DECISION DELEGATED TO DEVELOPMENT MANAGER

Application No: H03-0465-21 **Applicant:** Mr & Mrs Marshall
Proposal: Proposed Two Storey Side Extension and Single Storey Front Extension
Location: 19 Counter Drain Drove Tongue End Spalding
Terminal Date: 23rd June 2021

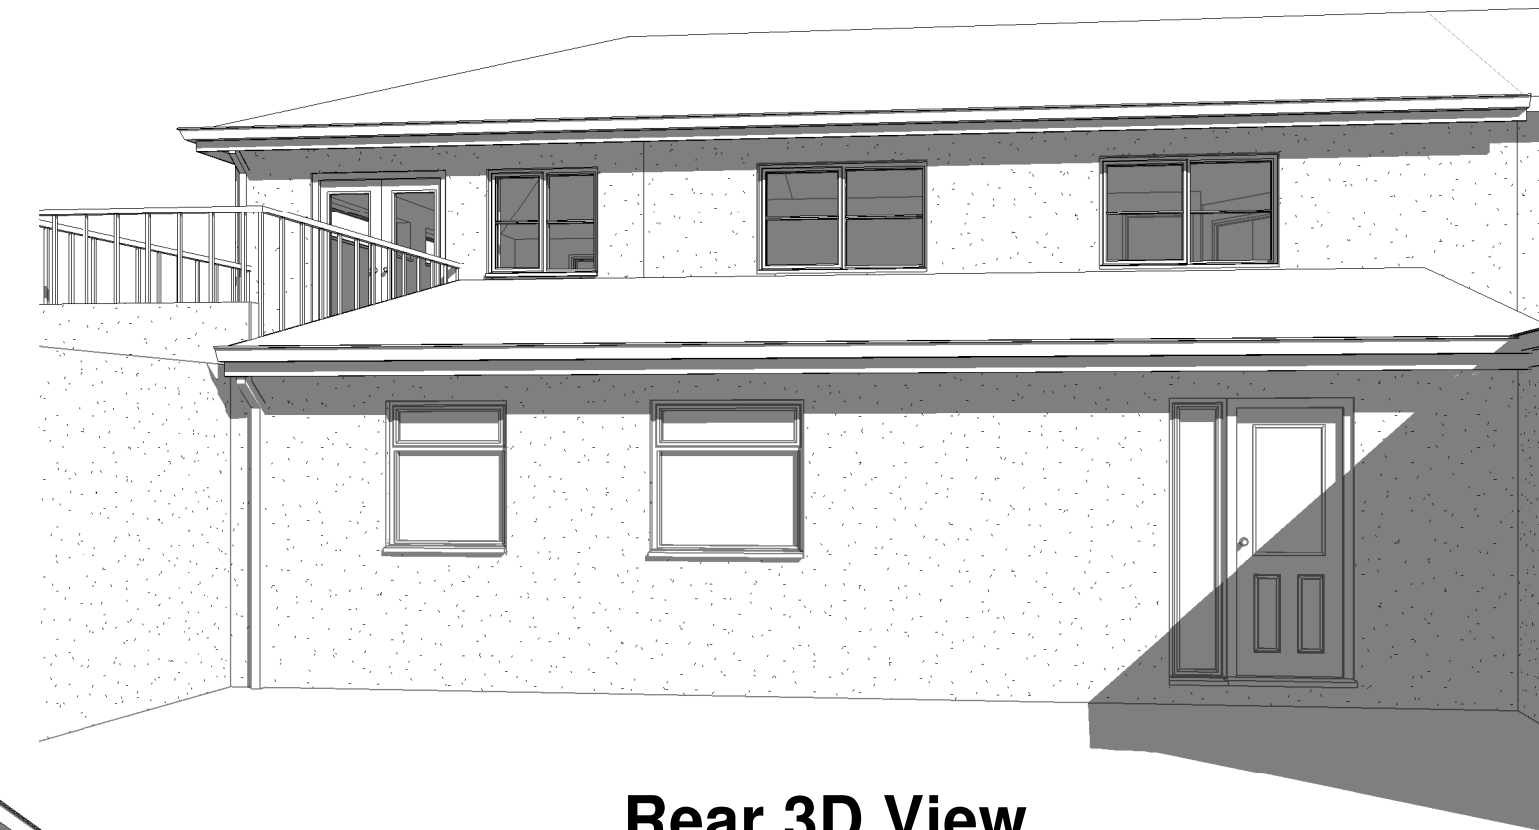
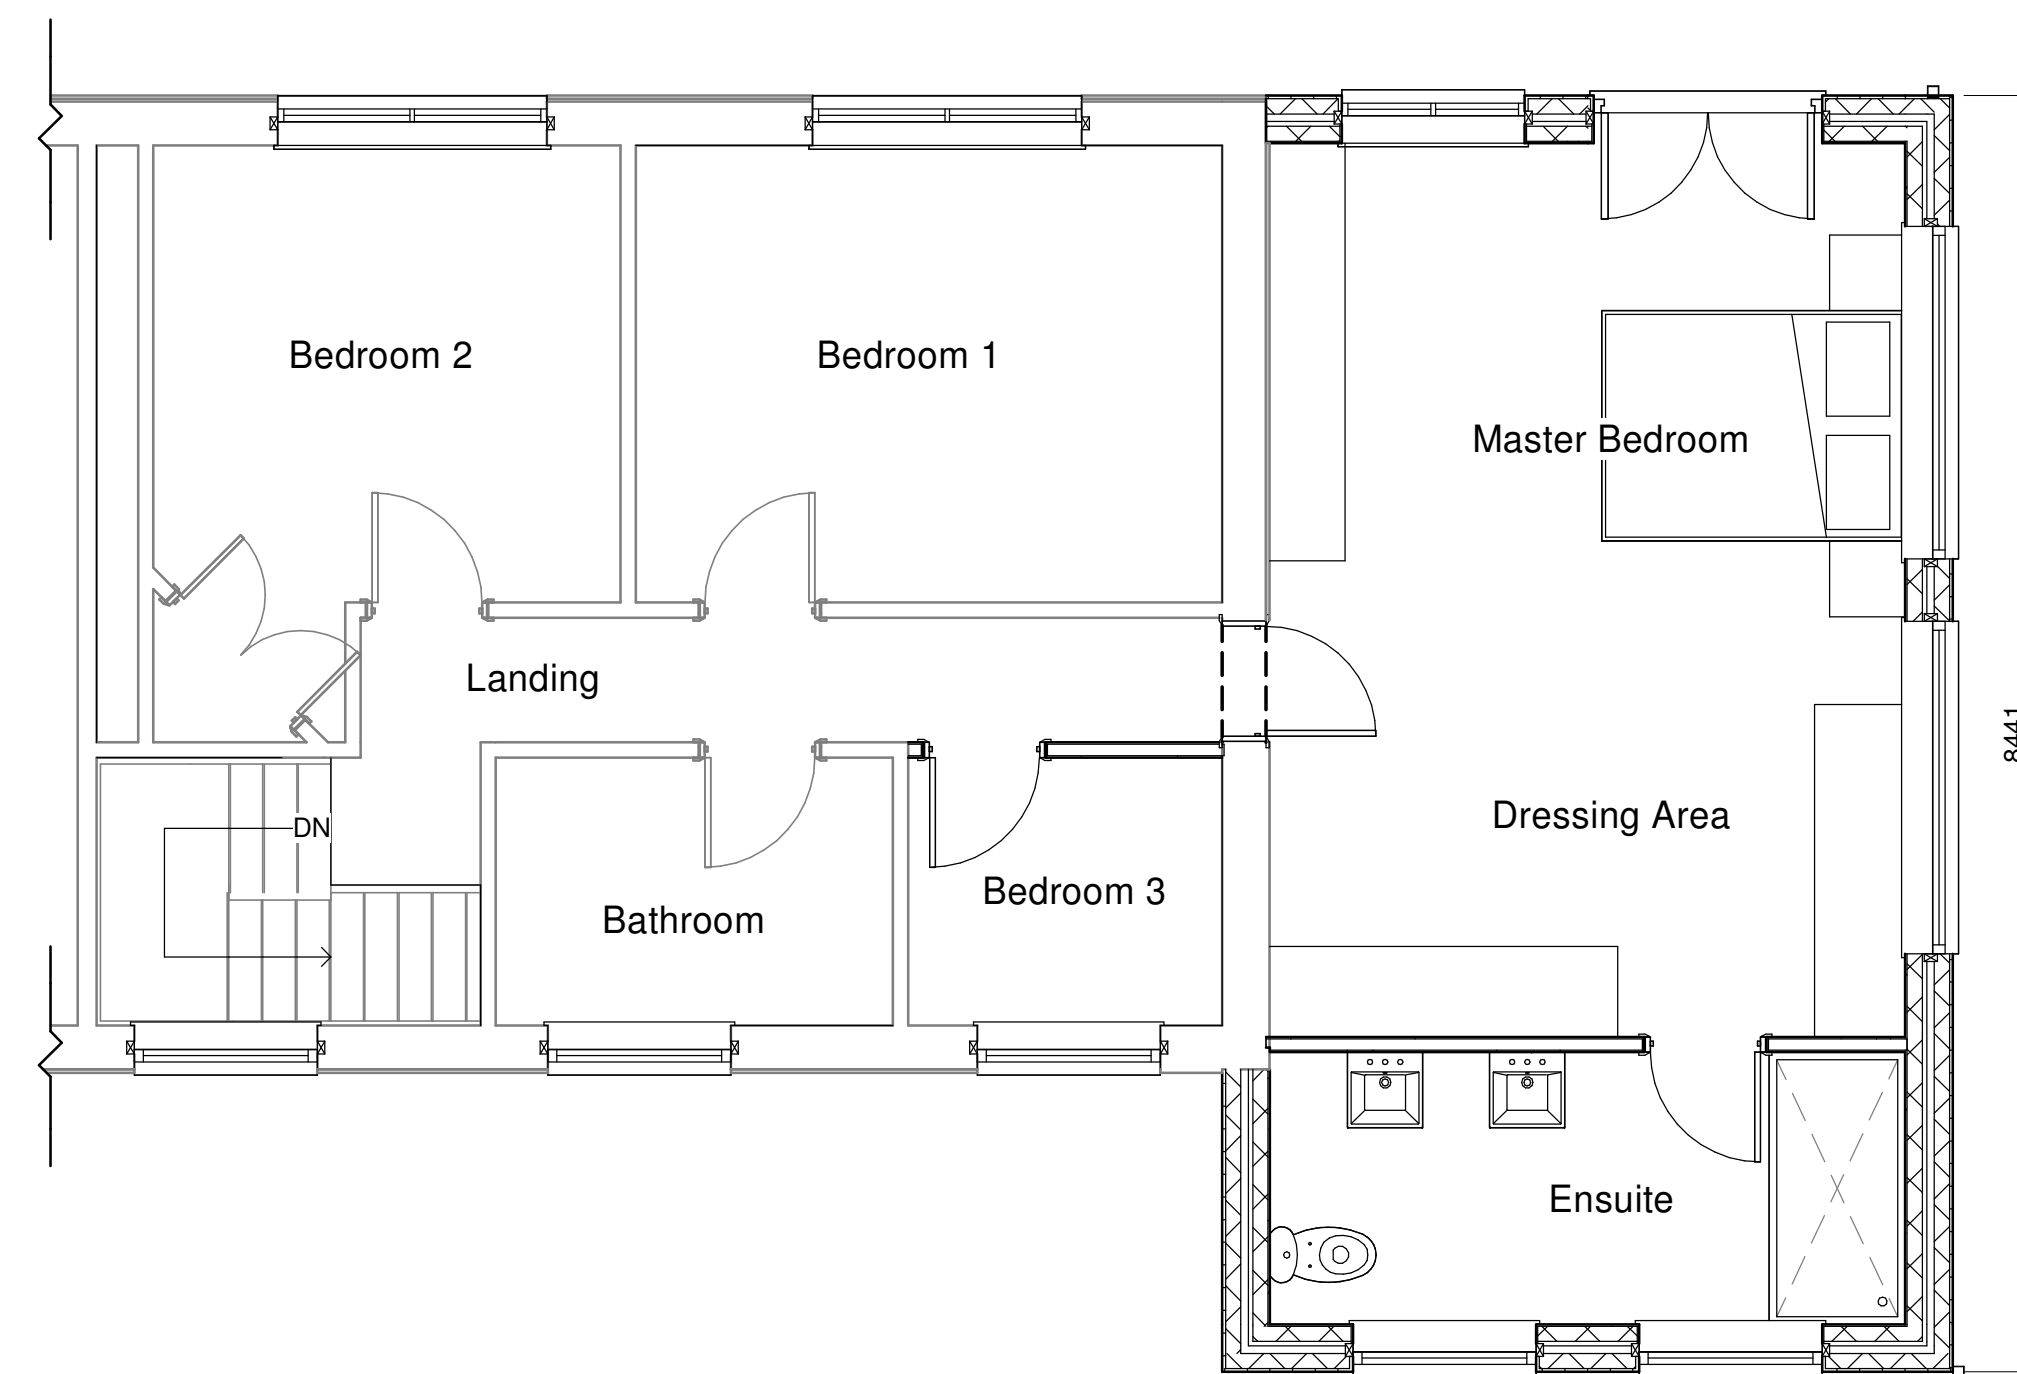
The neighbour at no.18 raised objections to the balcony/roof terrace initially proposed. The concerns were accepted and it was considered that the roof terrace would result in unacceptable overlooking into neighbouring properties. As such the scheme has been amended and a Juliette balcony with no access to the flat roof element is now proposed. The amended scheme is considered acceptable as the view from the Juliette balcony is not considered to have a greater impact than a window therefore this element can be accepted as it would only have direct views of the open countryside to the rear and not the neighbouring dwellings.

It should be noted that the plans have been amended and the balcony/flat roof terrace initially proposed has been replaced with a Juliette balcony.
